TRAFFIC IMPACT STUDY

I68 Training Facility Development
El Paso County, Colorado
PCD File No.PPR2440

October 2024
Revised December 2024

Figure 8
TOTAL TRAFFIC - YEAR 2045
 Volumes & Intersection Geometry
 Sat / Sun Peak Hour
 (ADT) : Sat / Sun Average Daily Traffic

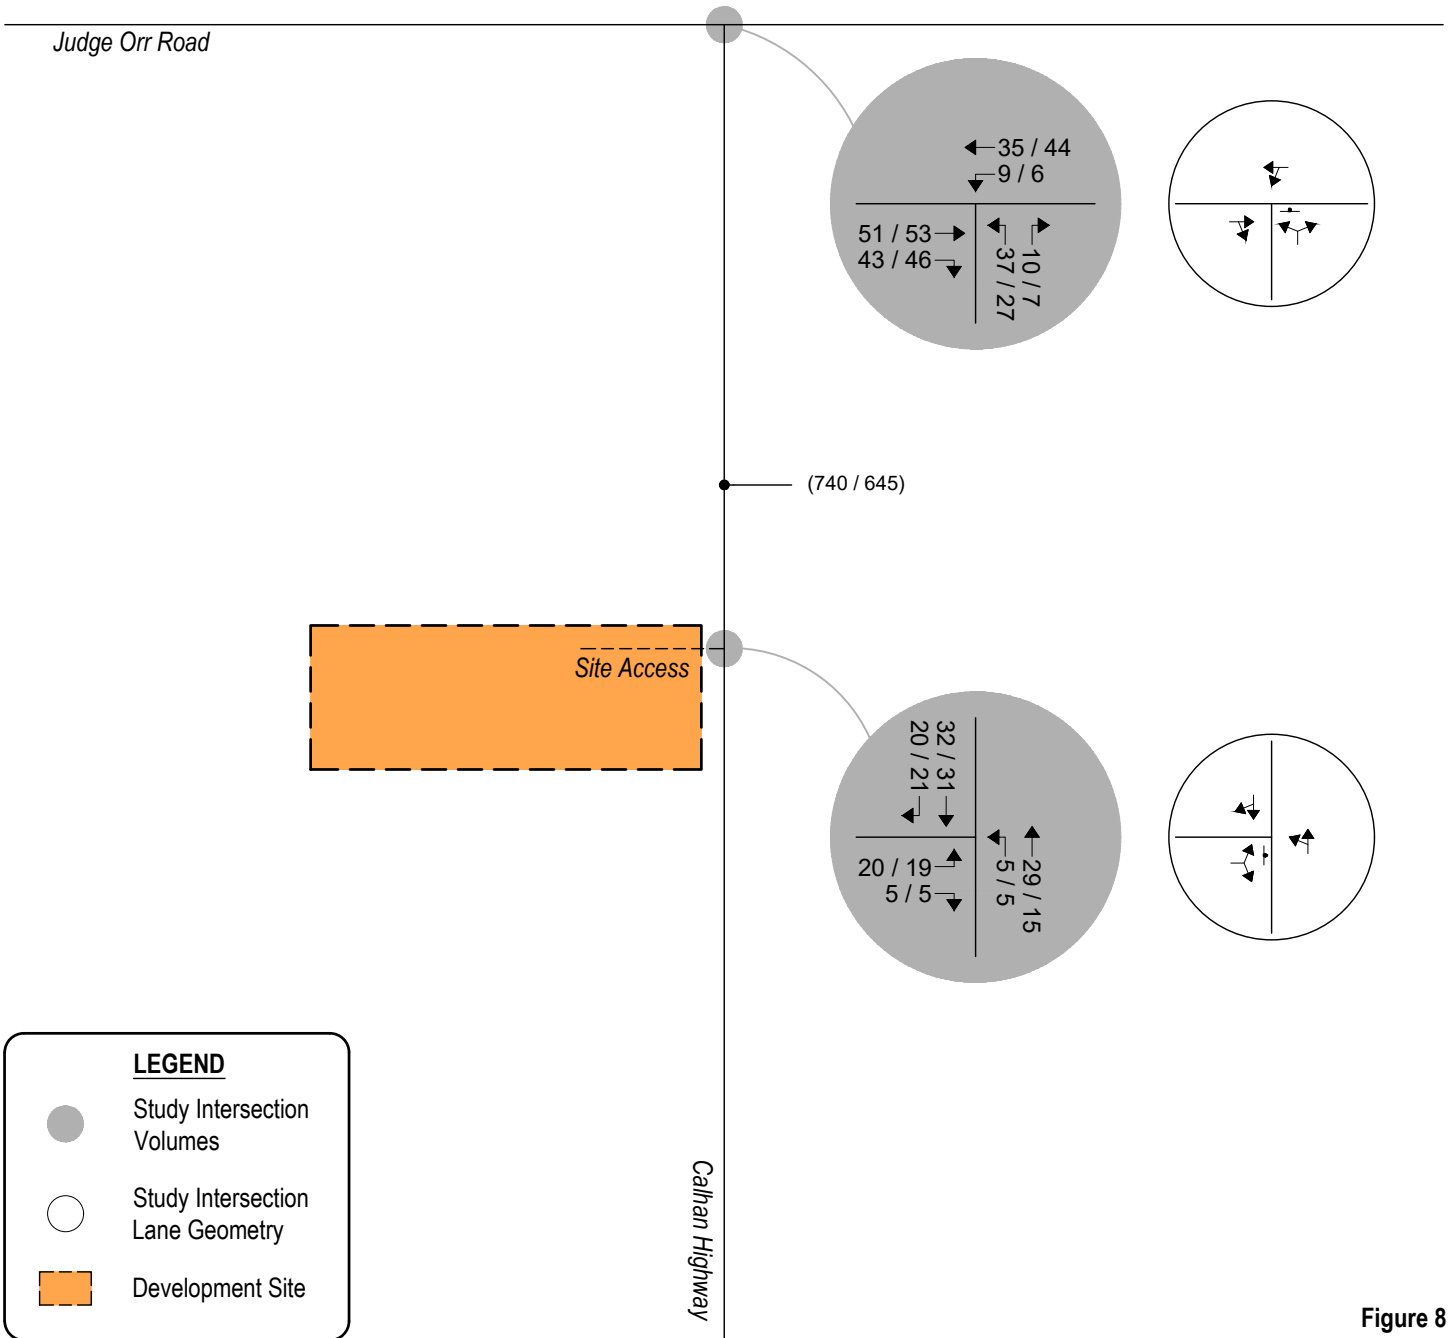
Please be aware that per the site development plan the connex city will be done at a later phase(4). Traffic analysis can be broken up into the proposed phases to see whether the aux. turn lane is triggered with what is only currently proposed. Feel free to call to discuss.
